Your Ref: OWPC25330
Our Ref: WA/7/19/RES
Please ask for:
Mr A Wood

Approval of reserved matters following outline consent WA/26/18/OUT for layout & scale for 6 No. dwellings & 6 No. detached garages.
Lanes End West Walberton Lane Walberton

PLOT 3 FLOOR PLANS AND ELEVATIONS

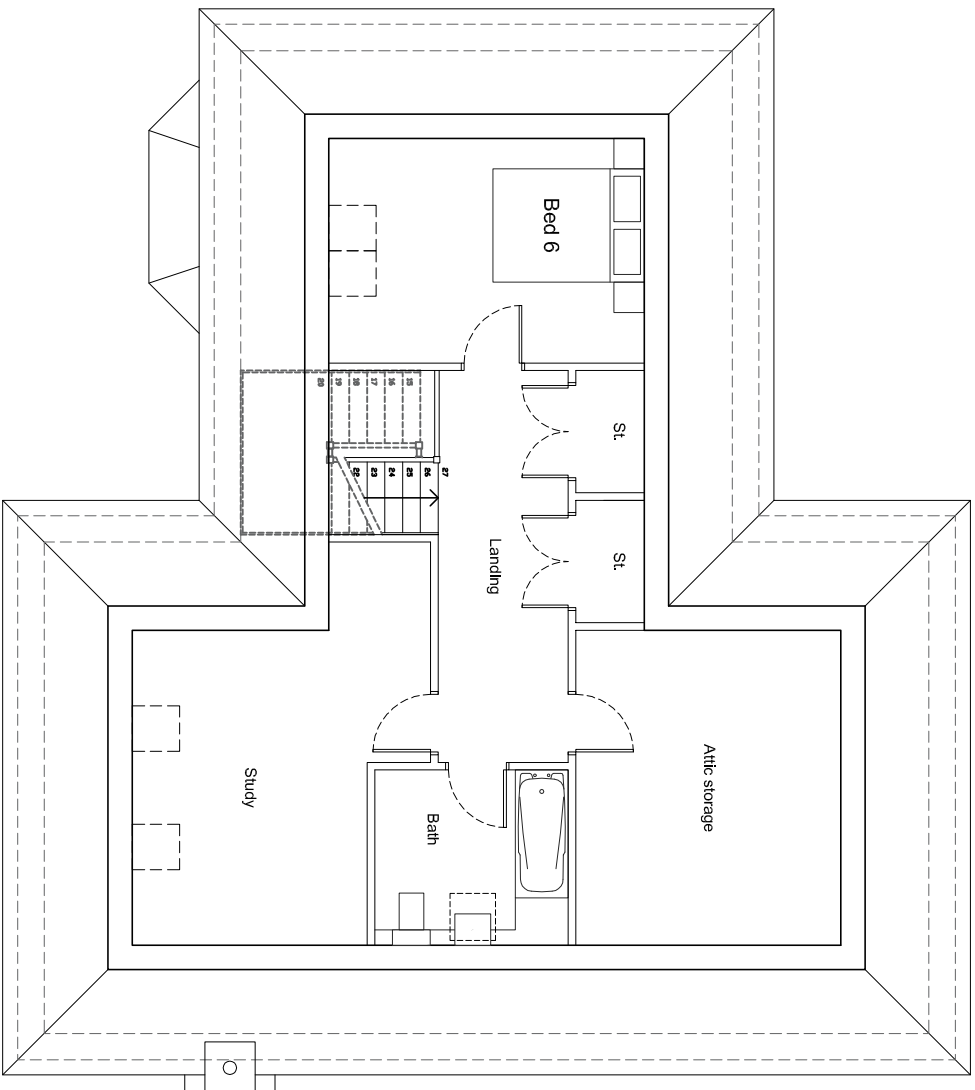
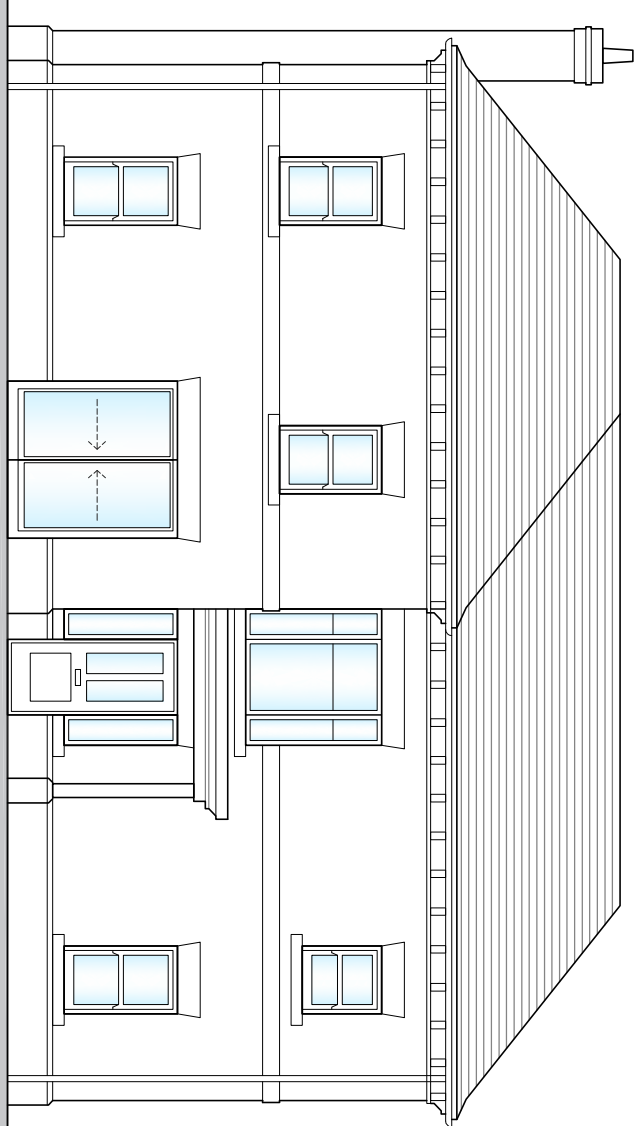
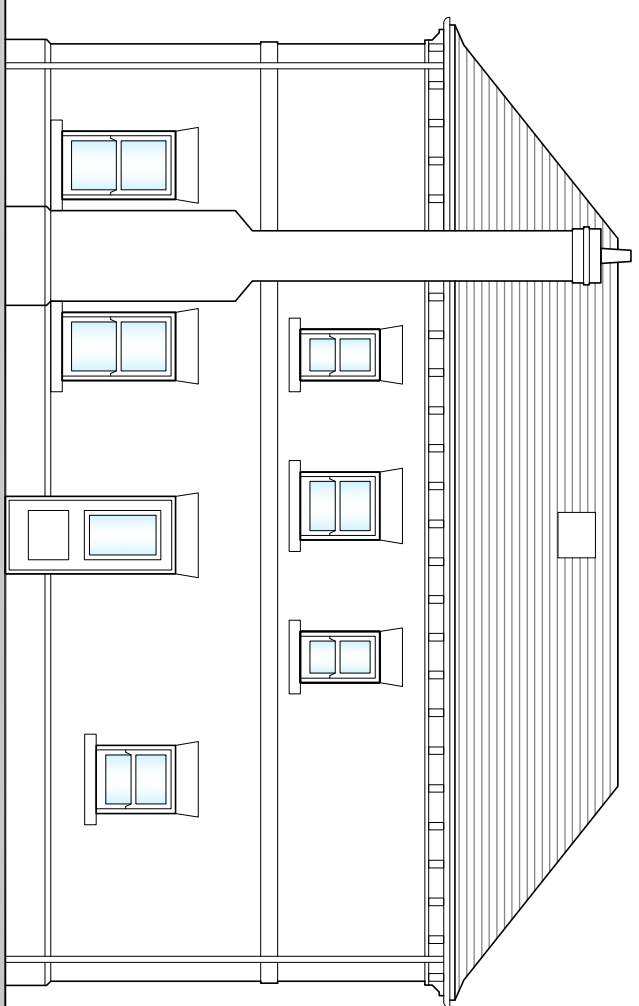
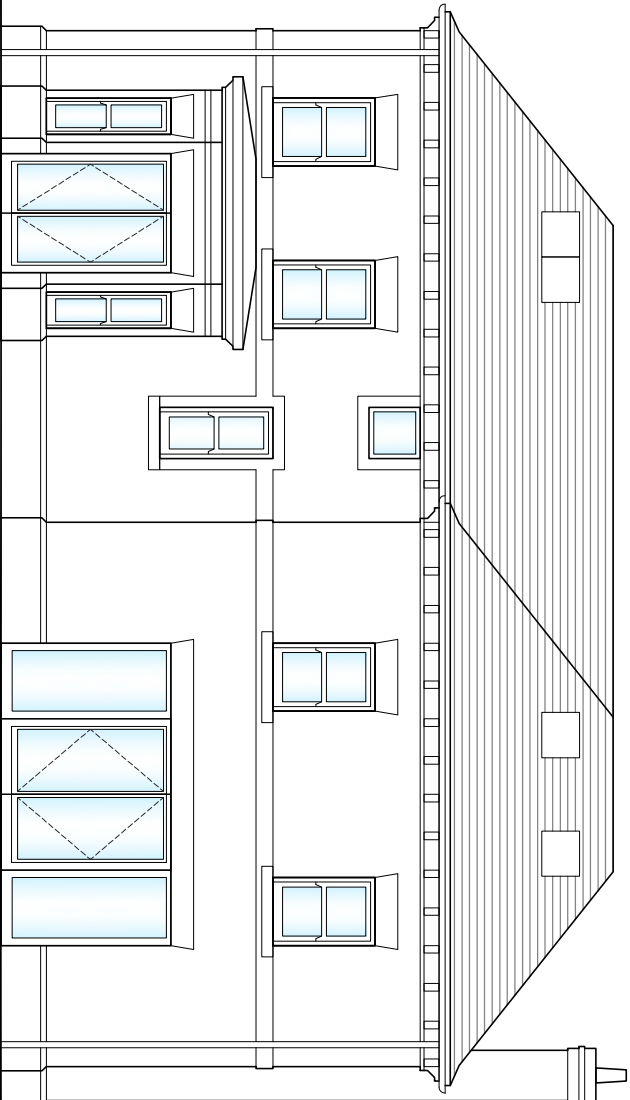
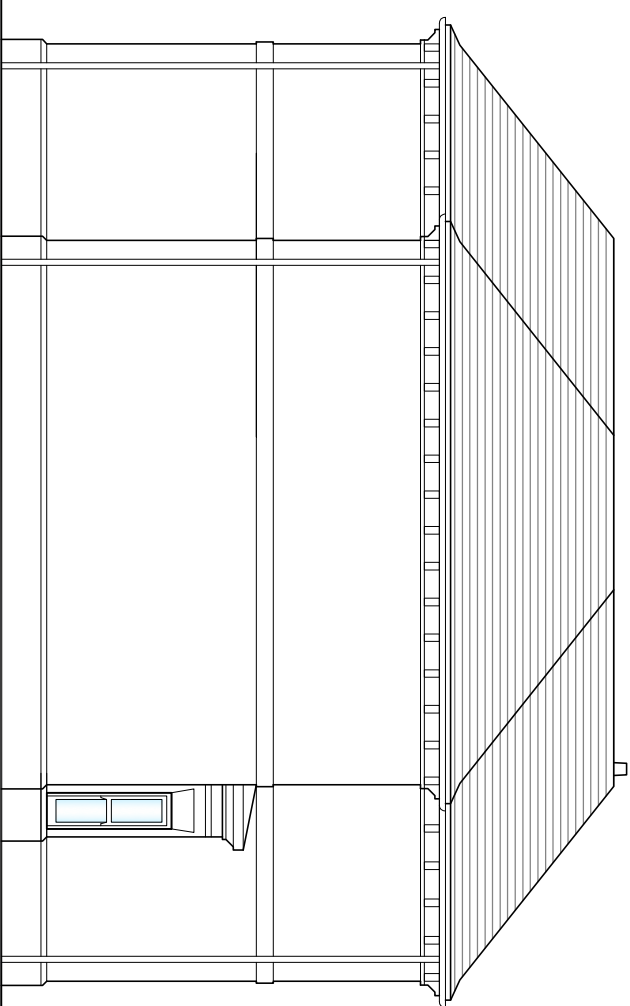
Arun previously said no to 3 stories and originally said no to any rooms in the loft. However, the response from the developer confirms 2.5 story. We still consider this out of keeping for the area and therefore inappropriate.
